**From:** Mark Warwick  
**Sent:** 06 November 2018 10:22  
**To:** Charlotte Easton  
**Cc:** Planning.Responses  
**Subject:** Prior Notification Of Works To Tree(s) In A Conservation Area - FP/213/18/TC

Application ref: **FP/213/18/TC**

Location: St Marys Church, Felpham Road, Felpham PO22 7NU

Works proposed: Reduce overhanging branches by 30-40m to 1 No Beech tree within the Felpham Conservation Area

Lime tree - St Mary's Church, Felpham Road, Felpham

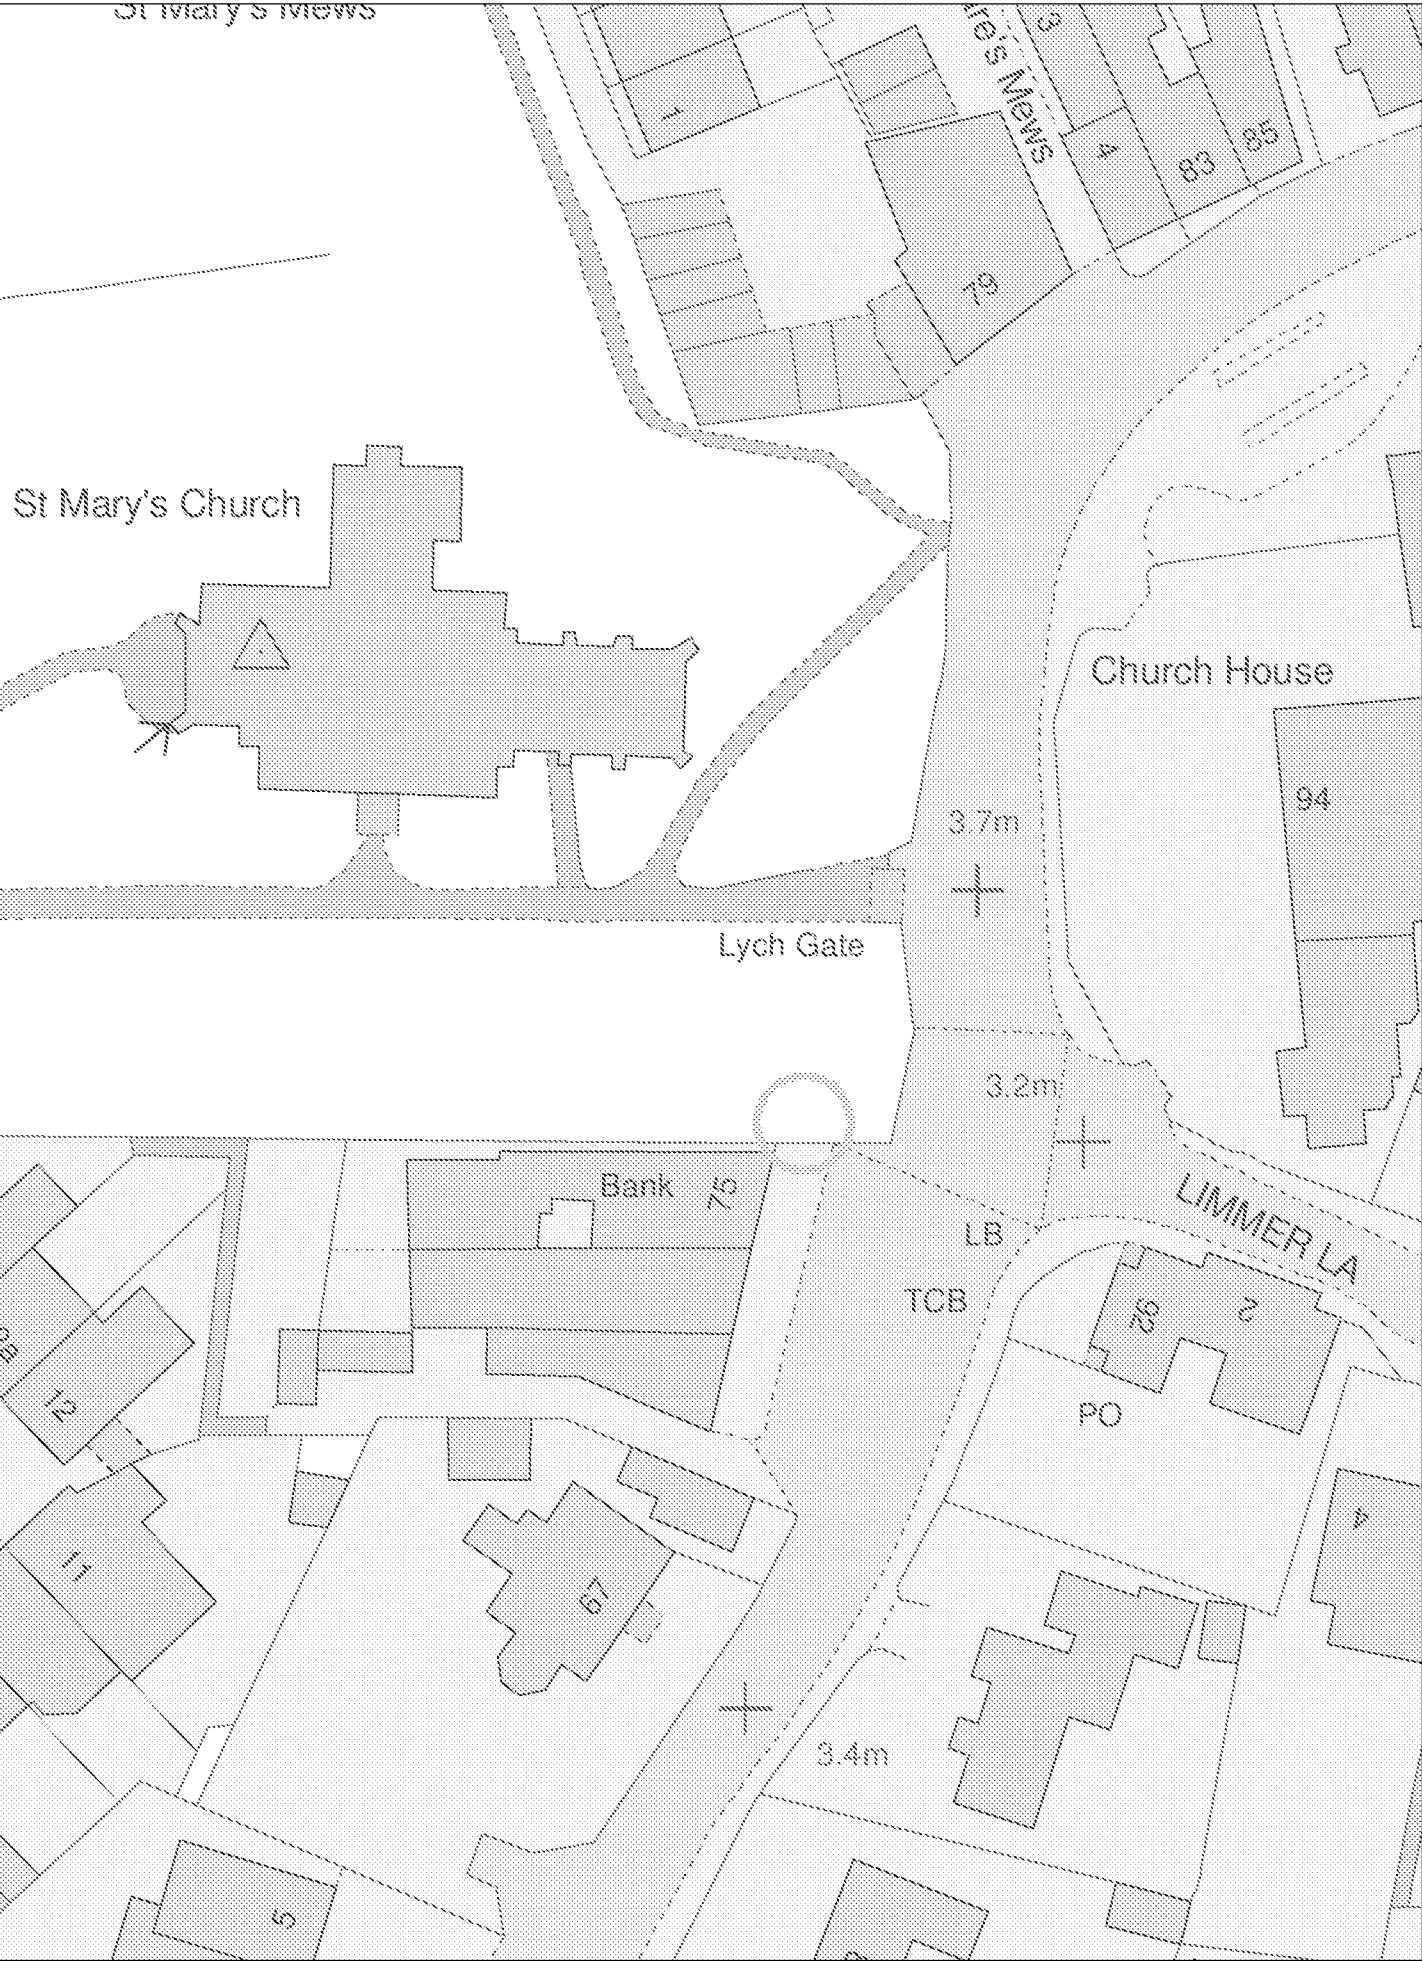
- i) The obvious candidate (tree) for pruning work to address building interference is an early-mature lime, not a beech as described.
- ii) The plan shows a linear tree group, parallel with the main (Felpham) road. The aforementioned lime is one of five that run alongside the building (Deligo sandwich bar/deli) and across the cemetery's south boundary; perpendicular to the main road.
- iii) The work proposal '*reduce overhanging branches by 30-40m*' is possibly an error in translation although an assumed 3-4m clearance would still be excessive and spoil the appearance of this tree.

*Prune back branches to achieve a maximum of 1.5m building clearance and 6m overhead clearance across property frontage.*
